APPLICATION **FG/4/19/DOC**
NO:

Site Address: Garage Premises Littlehampton Road Ferring BN12 6PB

Description of Works: Approval of details reserved by condition imposed under ref FG/39/18/PL relating to Condition No 7 hard & soft landscaping and Condition No 11 control of car transporters & deliveries.

WEST SUSSEX COUNTY COUNCIL CONSULTATION

Drawing Title
**Proposed Hard & Soft Landscaping
Plan**

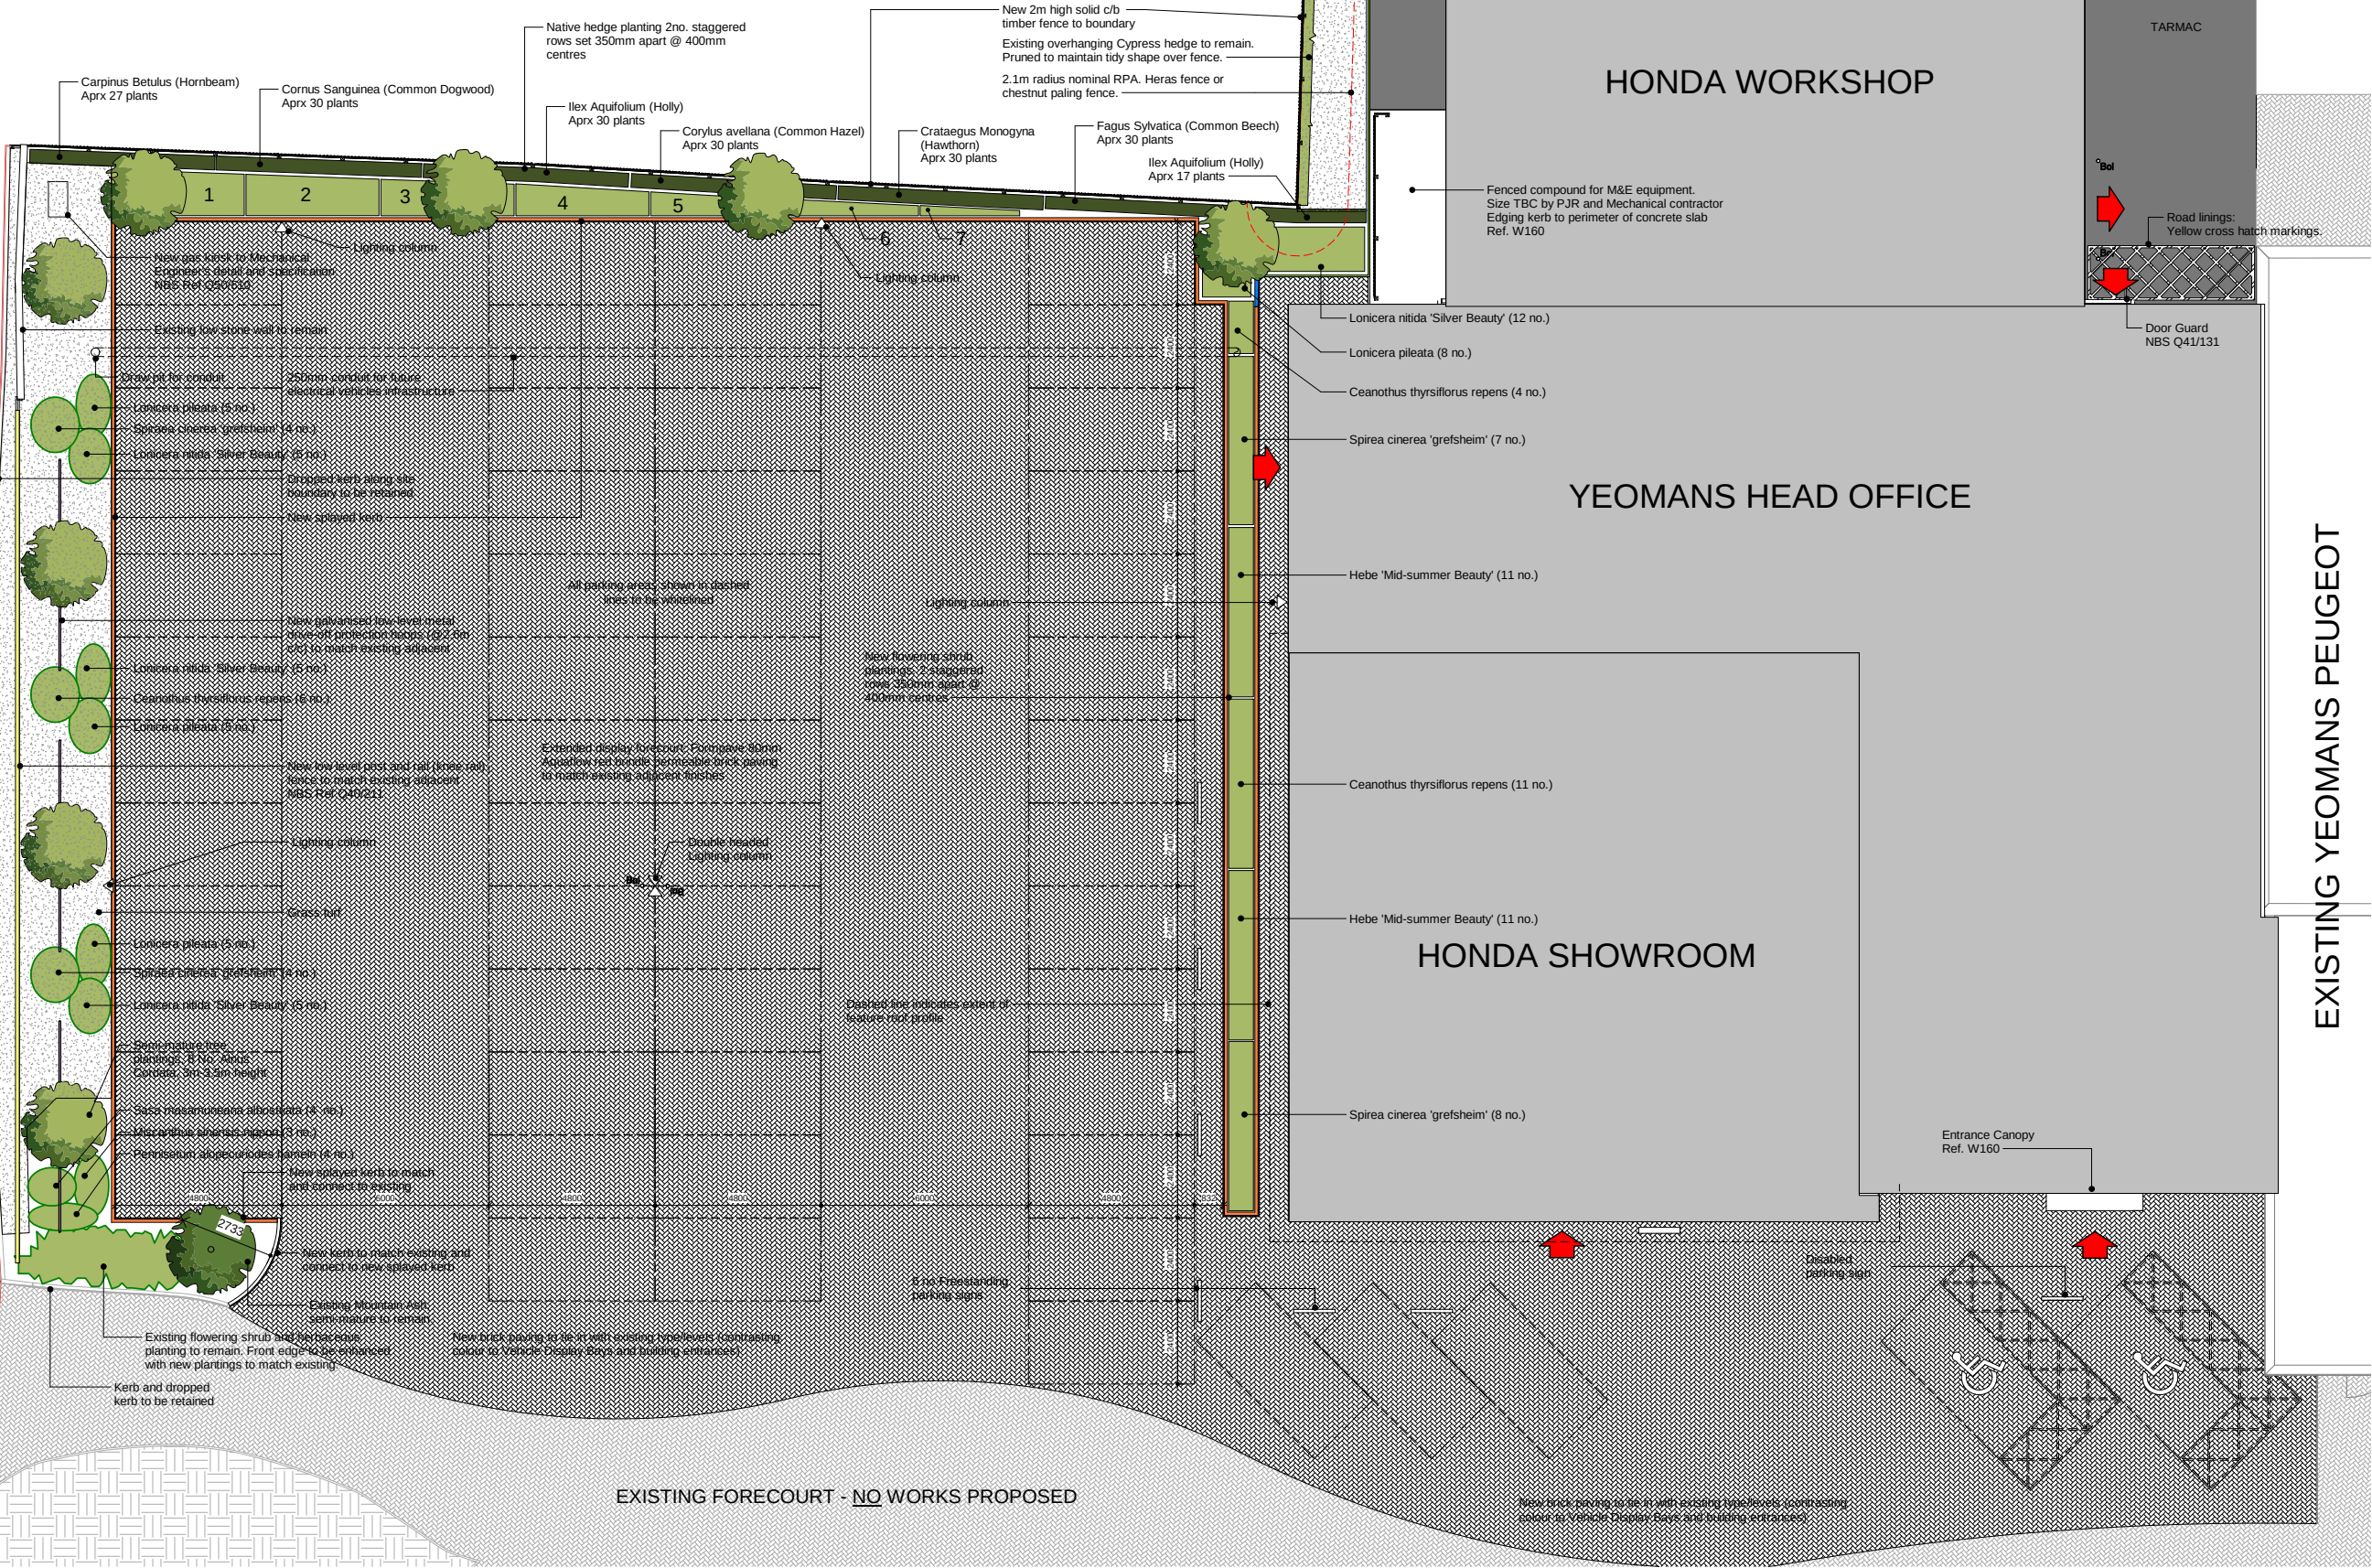
Condition 7 – Hard and soft landscaping. Not generally highways related, however parking spaces are clearly marked on the plan.

020.0347.001

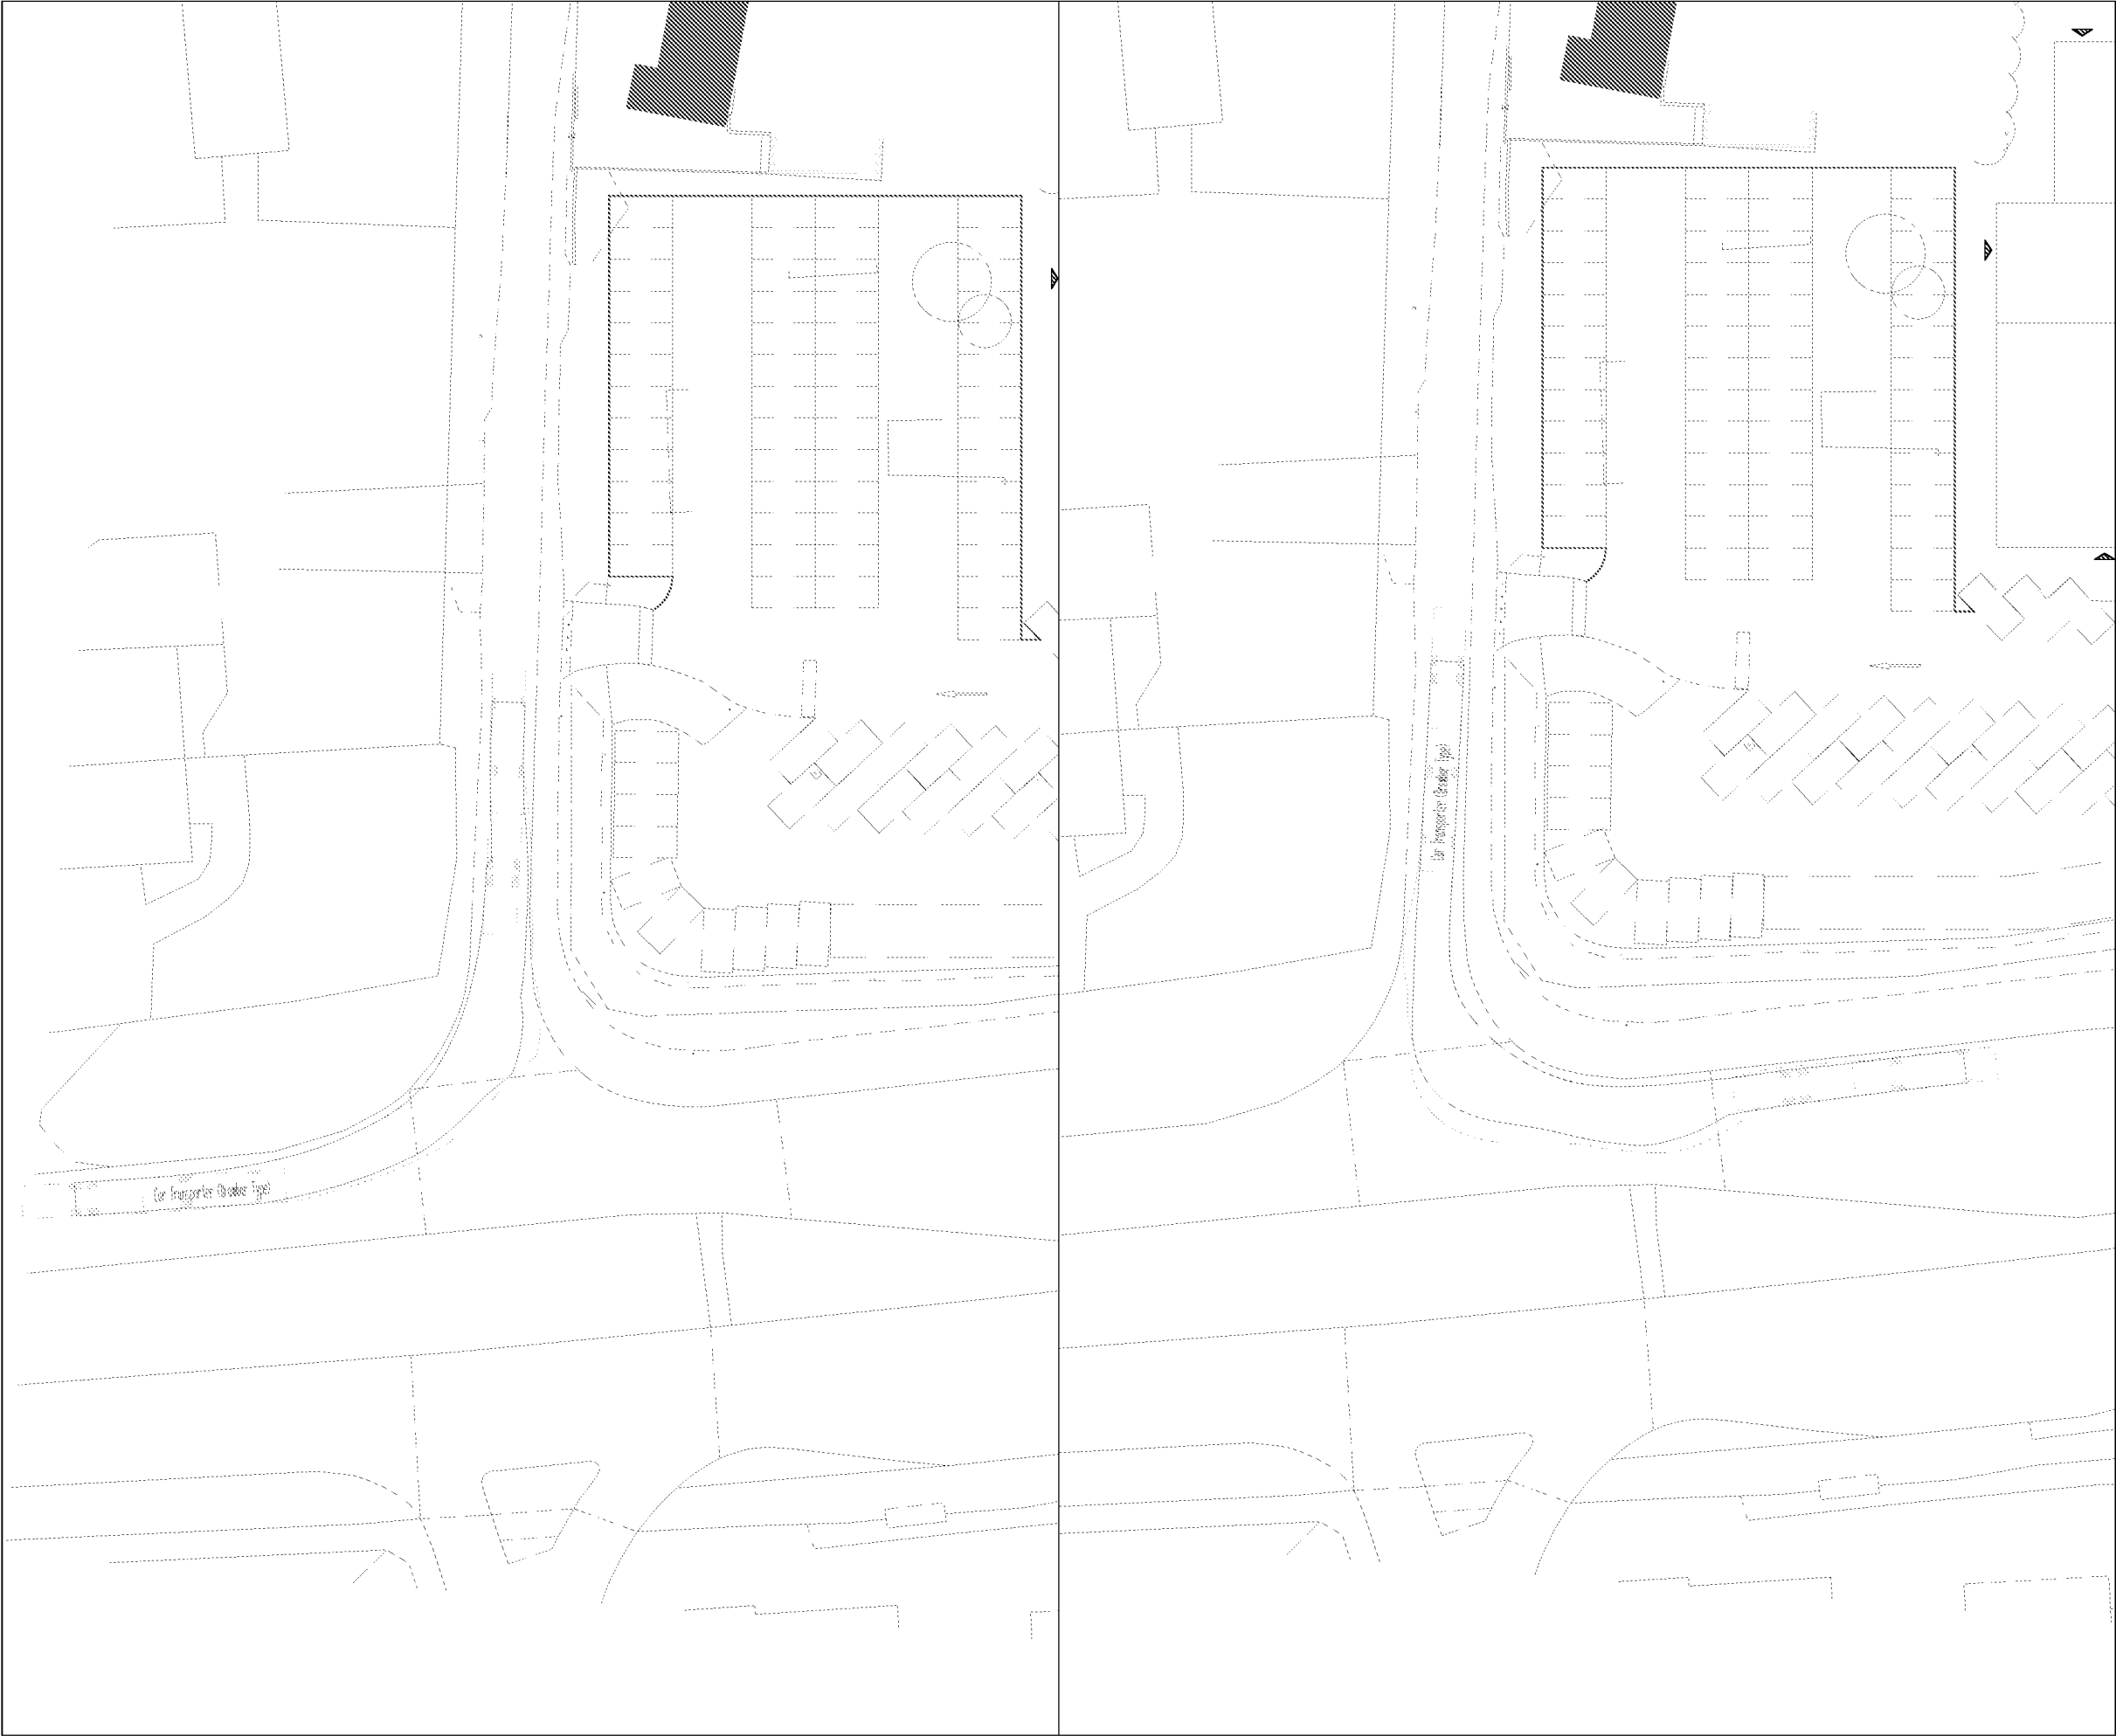
In addition, the indicative widening works to the access in Hangleton Lane shown on Drawing 020.0347.001 forming part of PA A/114/17/PL will need to be undertaken prior to occupation.

APPENDIX D – CRANAGE

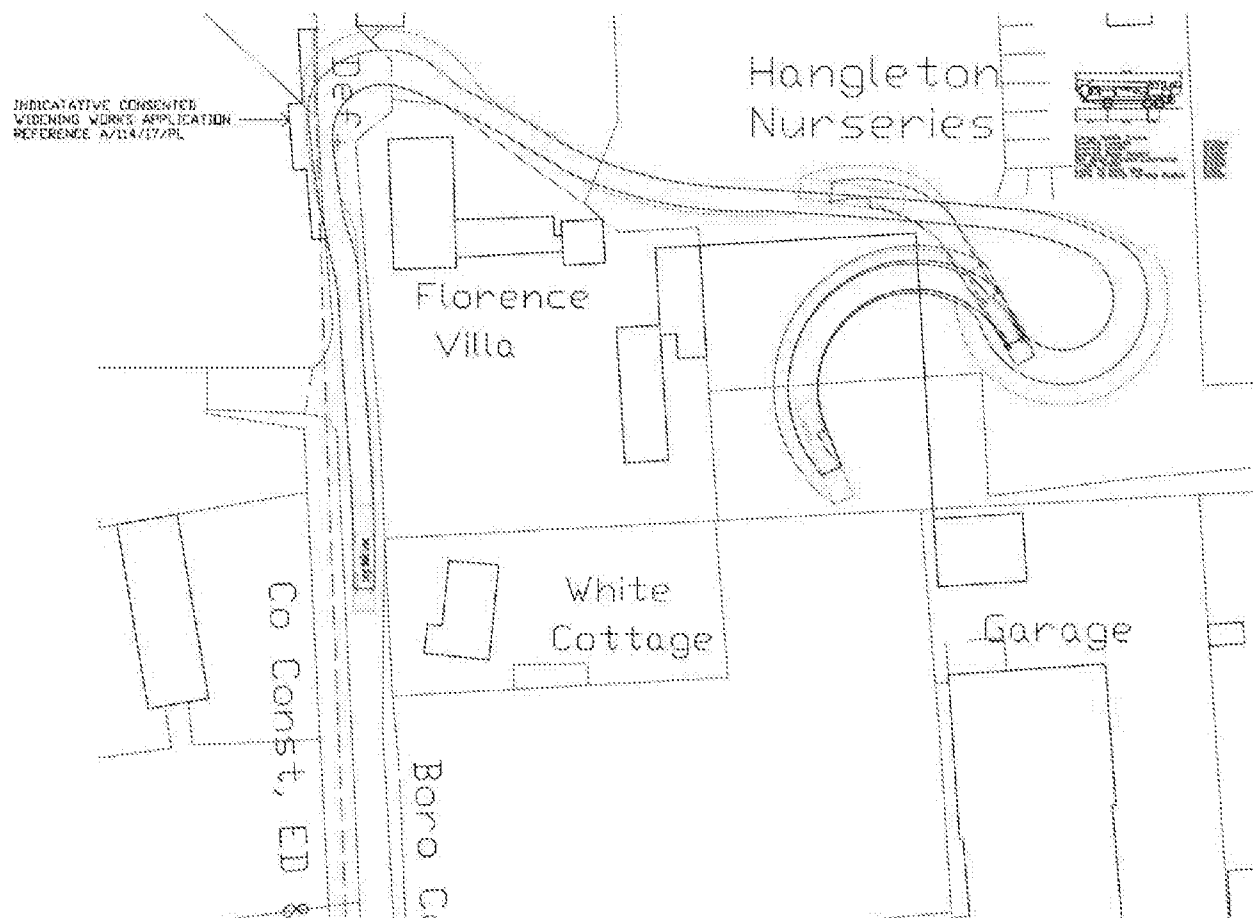
In reference to our previous response dated 14/1/19 to FG/171/18 for the Discharge of Conditions – Construction Management Plan. It may be helpful to request the applicant shows the swept path of the Crane on a drawing which also shows the widening permitted under PA A/114/17.
